# ETHOS URBAN

## Response to Public Individual Submissions

Redevelopment of Greenwich Hospital

27 September 2019 | 2190376

DRAWING TITLE:
SHADOW DIAGRAMS - WINTER SOLSTICE
12pm
DATE:
AUGUST 2019
DRAWN:
EC
PROJ:
1213
PROJ ARCH:
BF
DRAWING:
IN.91
SCALE:
1:1000 @ A1
REVISION:
P2

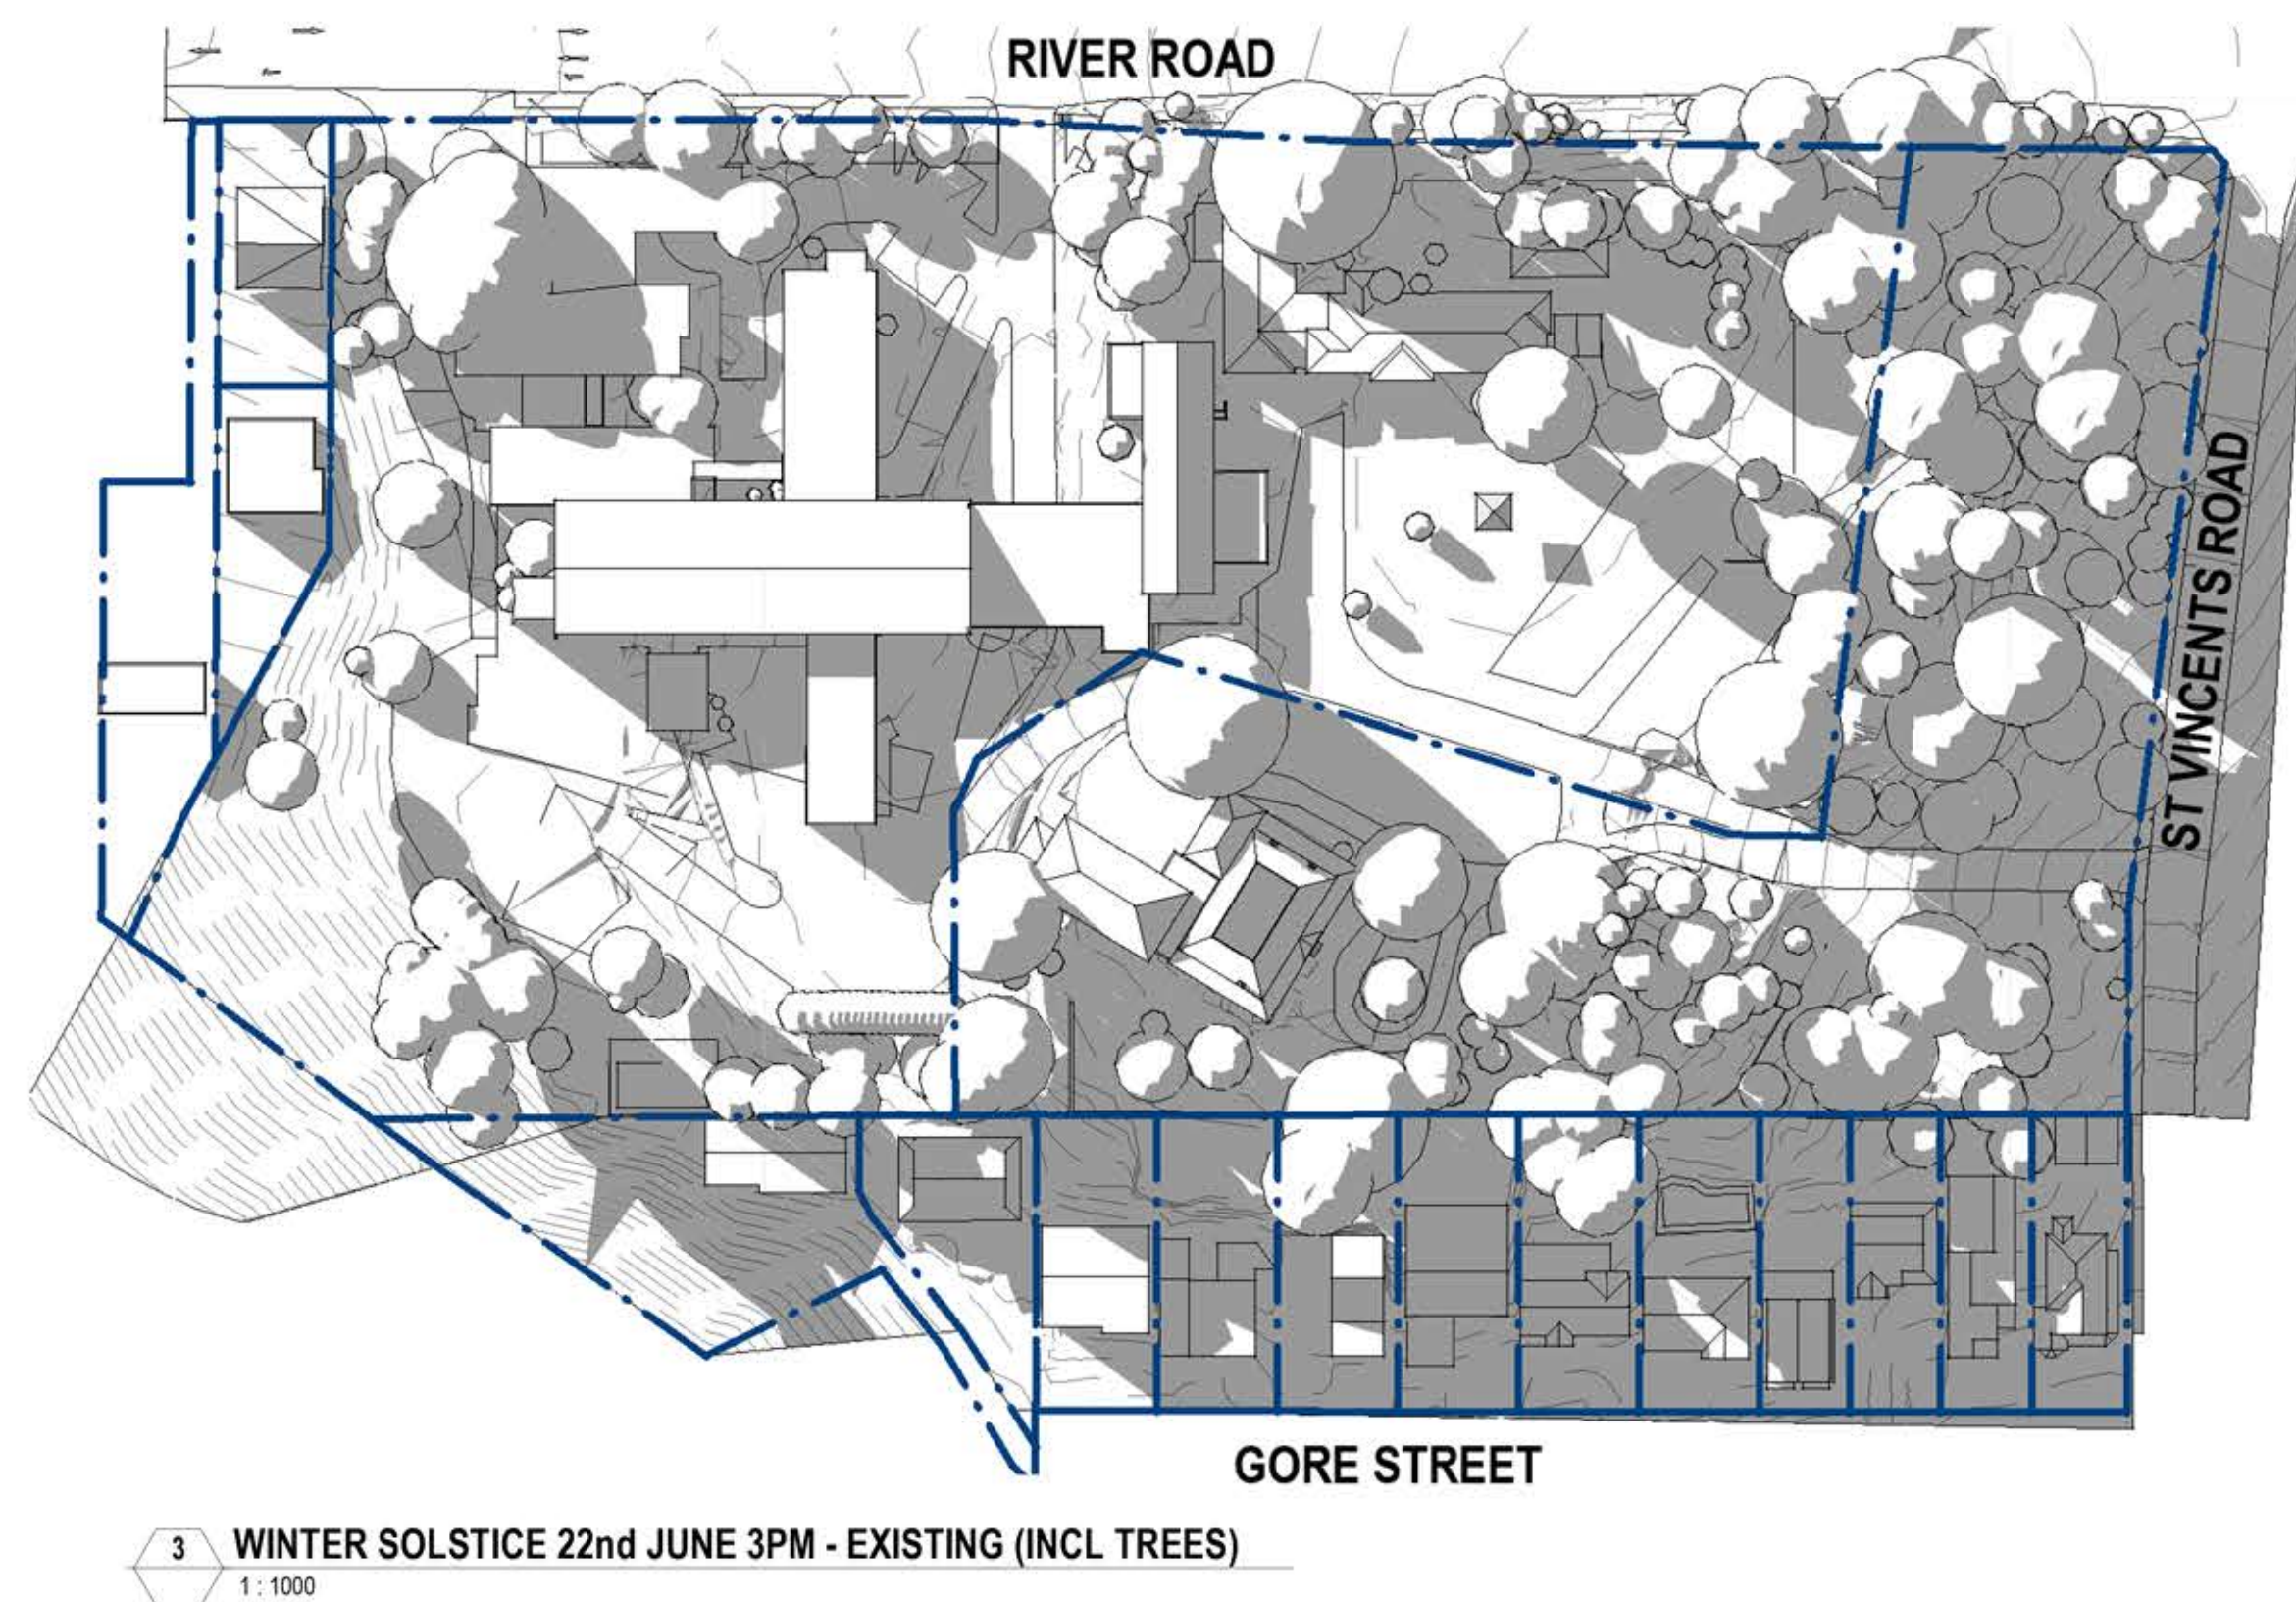
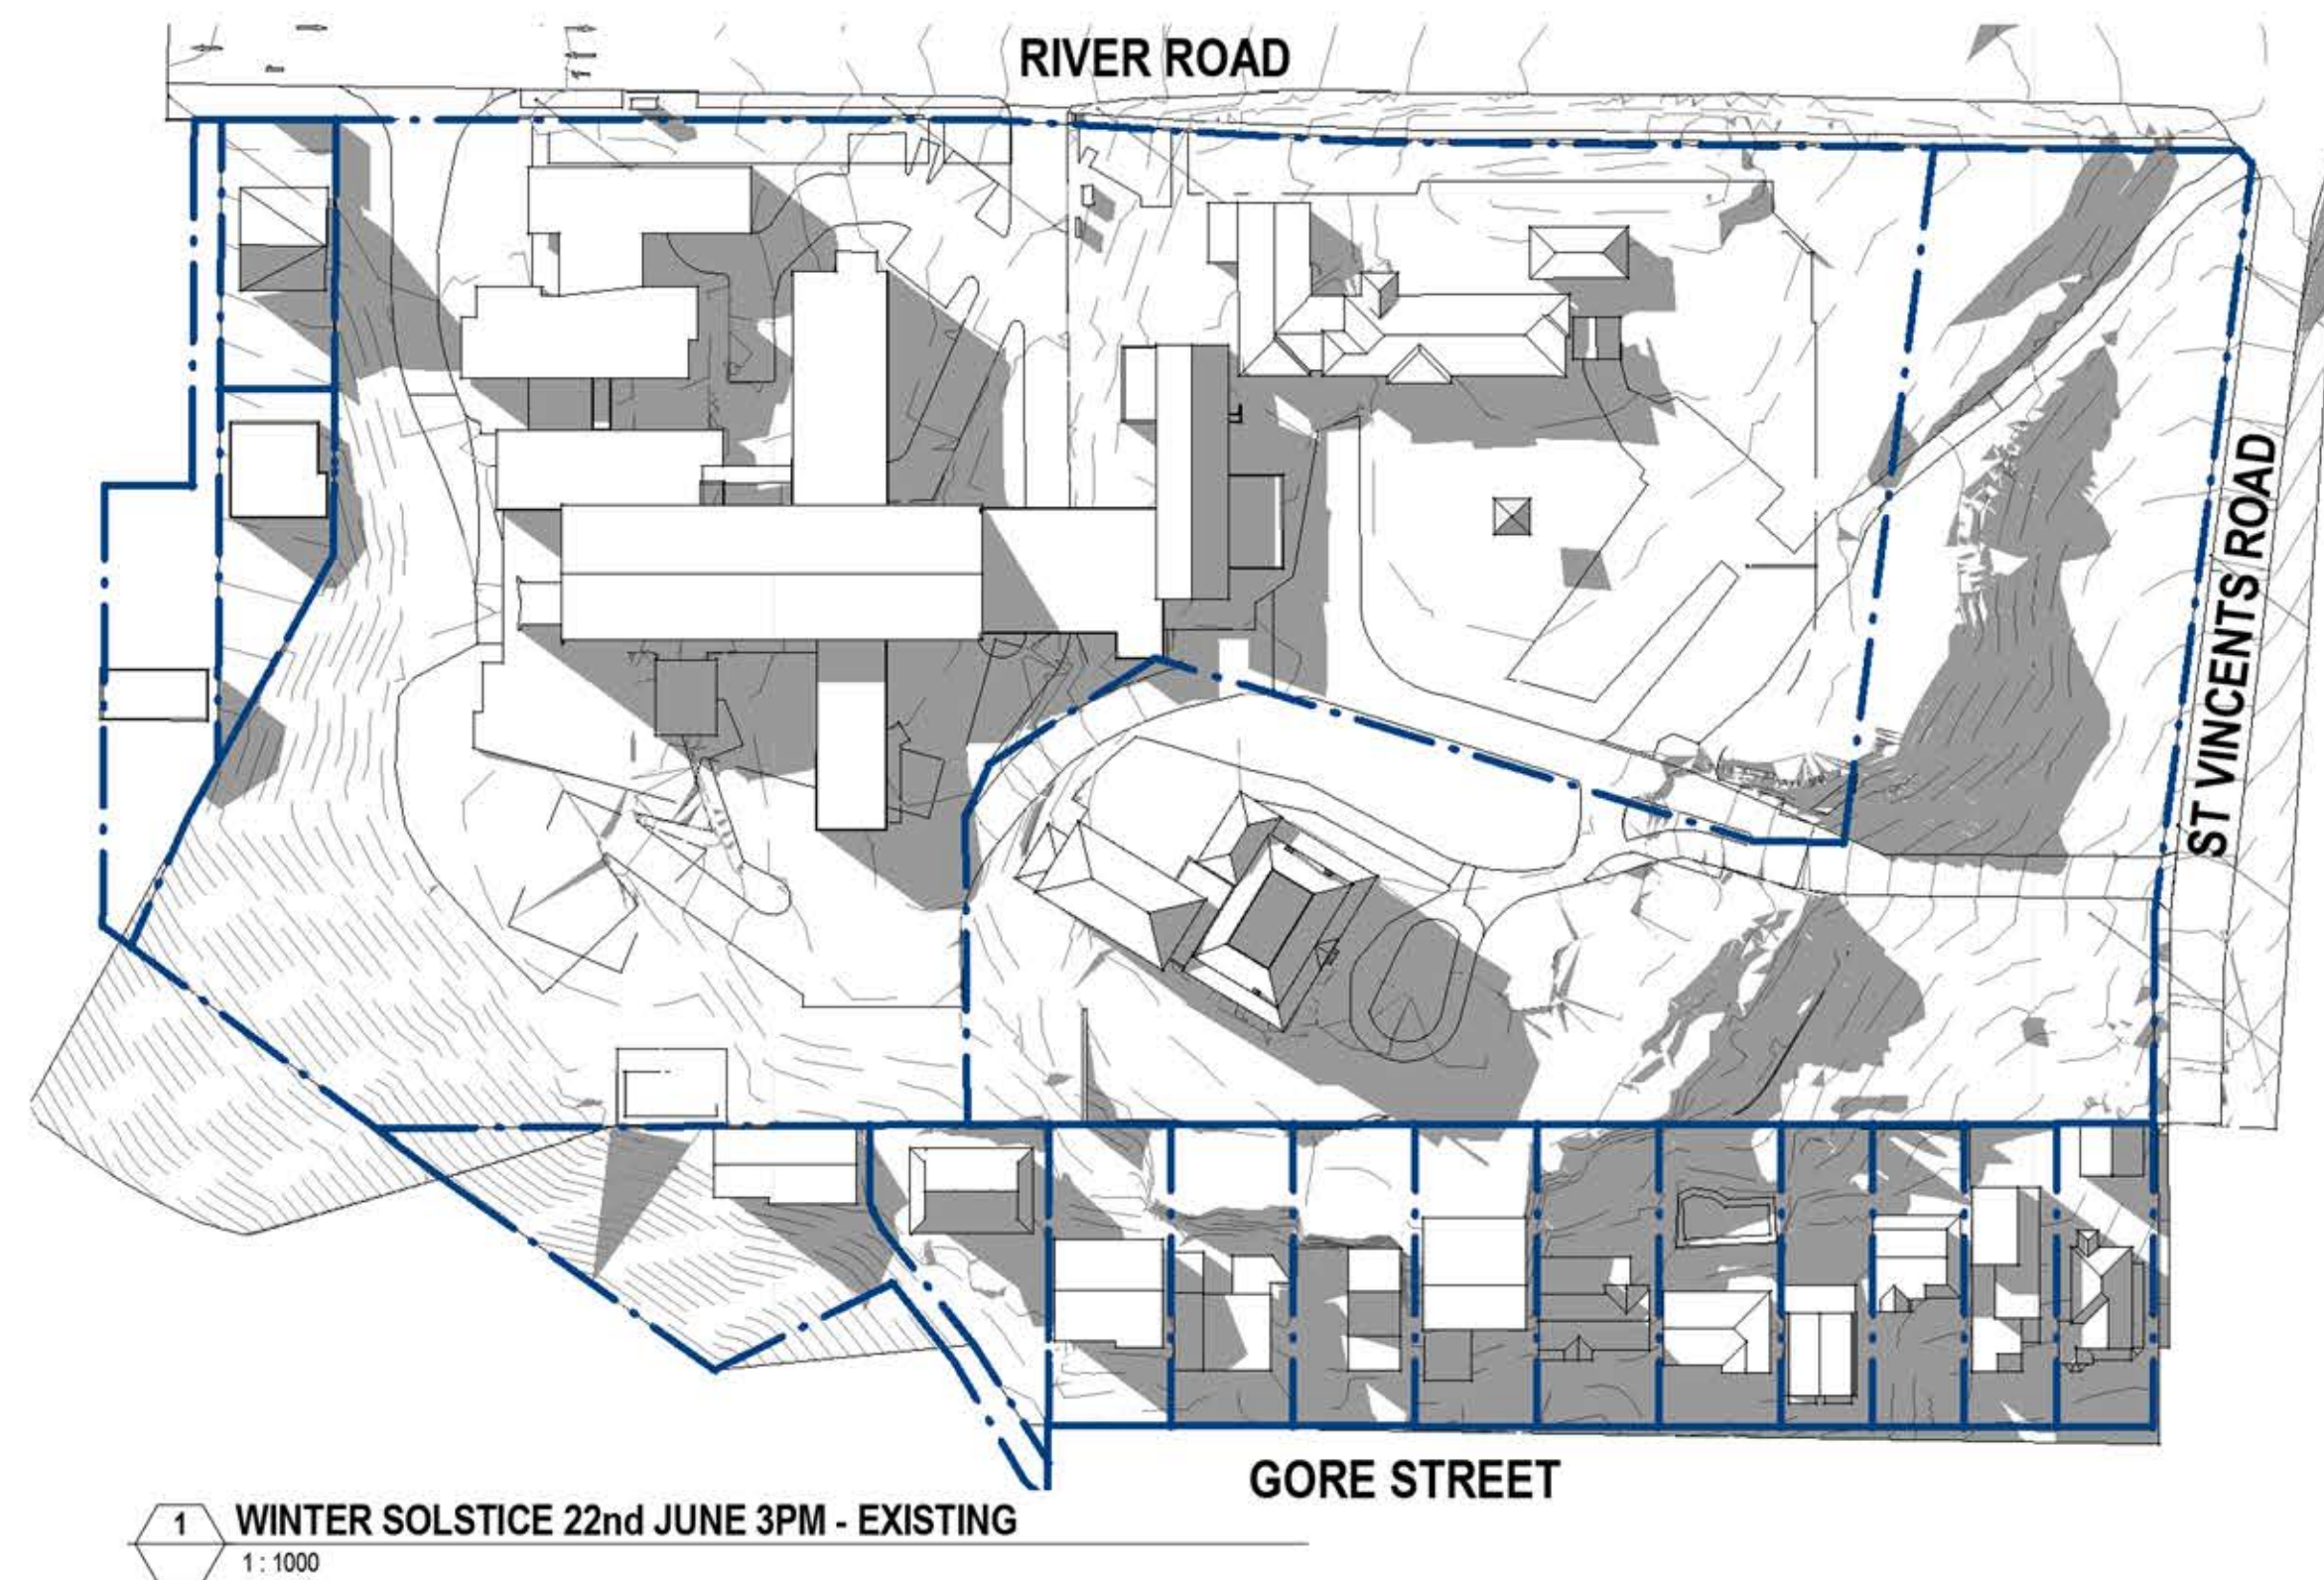
<b>Overshadowing</b>		
The development will result in excessive overshadowing	Shadow diagrams have been supplied as part of the Amended Architectural Plans prepared by Bickerton Masters at <b>Appendix A</b> of the RTS, demonstrating that only minimal overshadowing will be generated by the proposed redevelopment outside of the site.	12
Overshadowing onto Bob Campbell Oval	Shadow diagrams have been supplied as part of the Amended Architectural Plans prepared by Bickerton Masters at <b>Appendix A</b> of the RTS, demonstrating that no overshadowing will occur onto Bob Campbell Oval.	11
Overshadowing onto Gore Creek Bushland Reserve	Shadow diagrams have been supplied as part of the Amended Architectural Plans prepared by Bickerton Masters at <b>Appendix A</b> of the RTS, demonstrating that no overshadowing will occur onto Gore Creek Bushland Reserve.	7
<b>Traffic and Parking</b>		
Insufficient parking has been proposed	A Traffic and Parking Impact Assessment was submitted with the original application which concludes the proposed provision of parking is appropriate. Parking for the seniors living component complies fully with the rates stipulated in SEPP Seniors, with one space per unit plus additional visitor spaces; 163 parking spaces are proposed for the hospital to service the 150 beds/rooms. Public transport options are also available for the site, meaning a proportion of visitors will not elect to drive.	15
